DOCO comments for application 2025/93178- land at Penistone Road, Fenay Bridge, Huddersfield, HD8 0AW

Condition 32- lighting:

Condition 35- cycle store:

DRAWING TITLE:	Typical Shed Arrangement
----------------	--------------------------

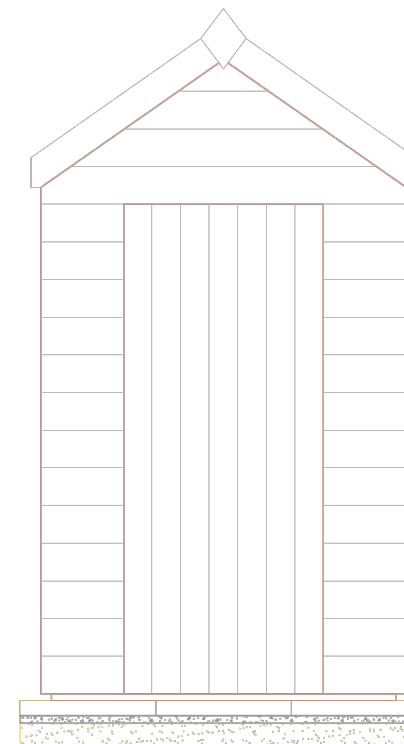
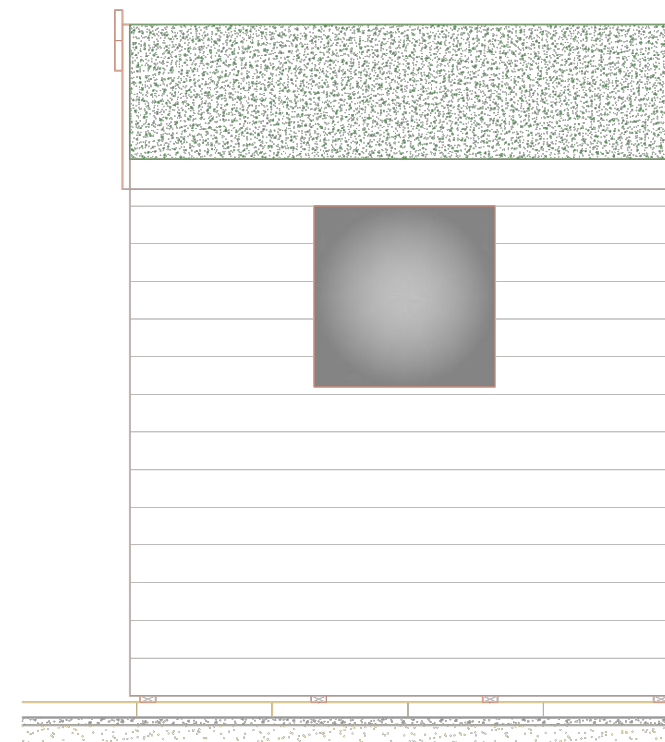
Could the applicant please clarify what security measures are proposed.

The shed/ cycle store should be securely fixed to the substrate foundation. Windows should be avoided. Hinges should be coachbolted through for extra security. Cycle store should contain a rated storage device inside, such as a ground anchor, stand or a rack. Minimum security standards are as per below:

Sold Secure SS104 Bronze, STS 225 Issue 2 Burglar Resistance BR1(S), STS 205 Issue 8 Burglar Resistance BR1, STS 225 Issue 2 Burglar Resistance BR1(S), LPS 1175 Issue 8 Security Rating A1, STS 501 Security Rating TR1 or STS 503 Security Rating TR1.

Figure 4. External dwelling lux plot (south)

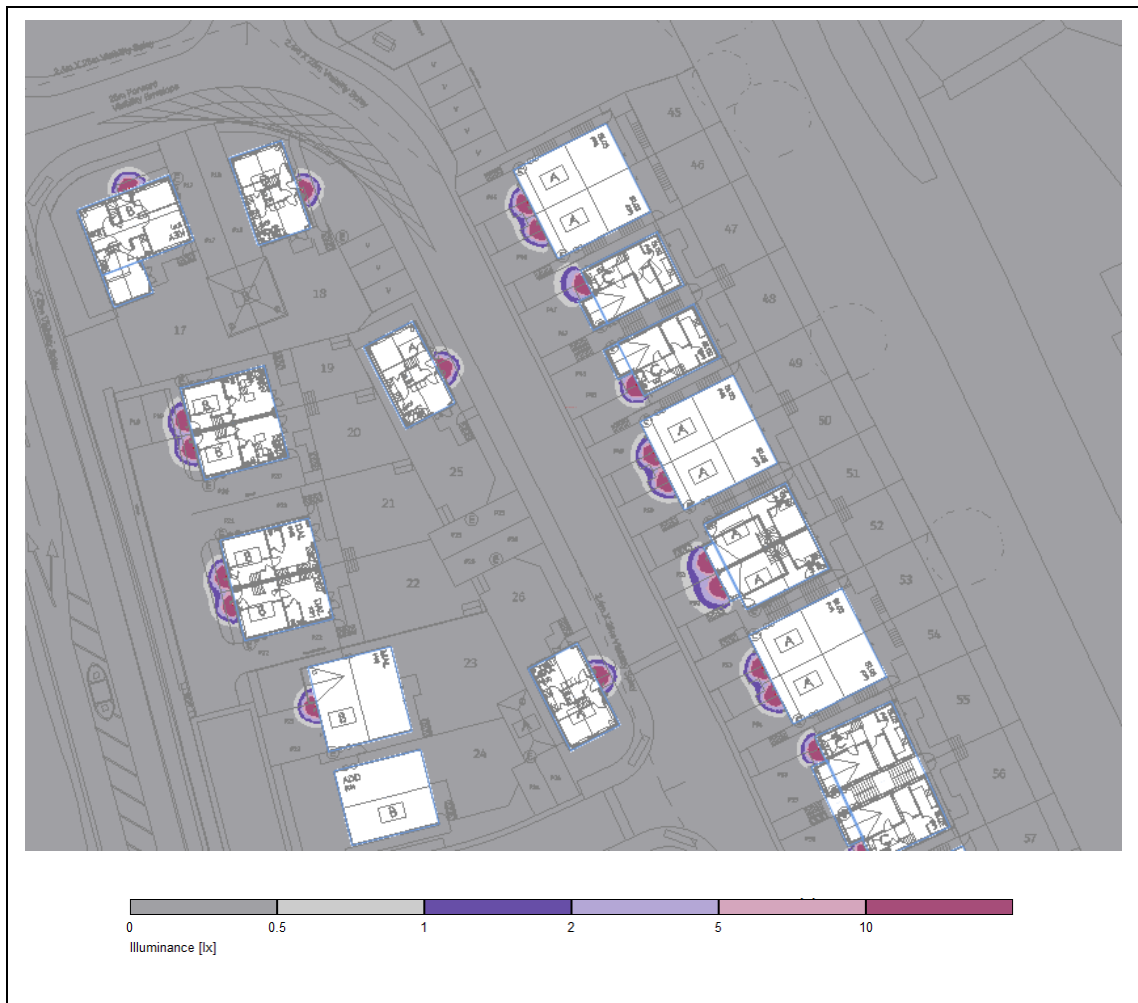
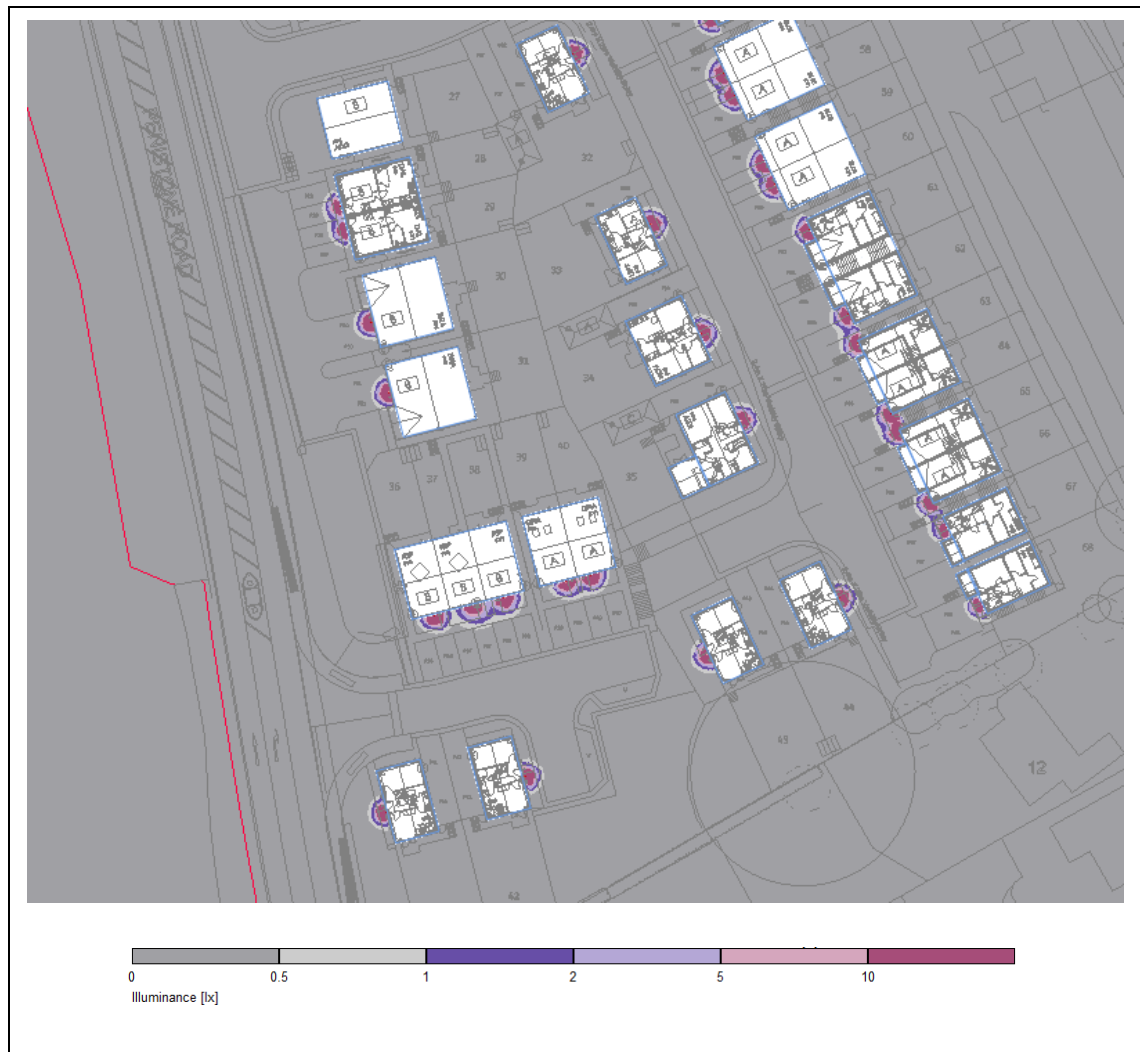
PIR-enabled external dwelling lights are not supported from a crime reduction perspective due to operational inconsistency, proneness to criminal damage, enhancing the fear of crime due to false activations and contributing to neighbour tensions due to the lights flashing on and off.

I note the remarks suggesting that the proposed luminaires would have a manual override function- however, from open source research, I believe they will automatically revert to the PIR mode daily, making it somewhat cumbersome for homeowners who wish to regularly use the override facility. Could they be replaced with dusk till dawn sensor luminaires instead?

Additionally, all external doorsets- not just the front one- should be illuminated by dusk till dawn enabled lighting so the doorways are observable and intruders easier to spot in the hours of darkness. This includes patio doors.
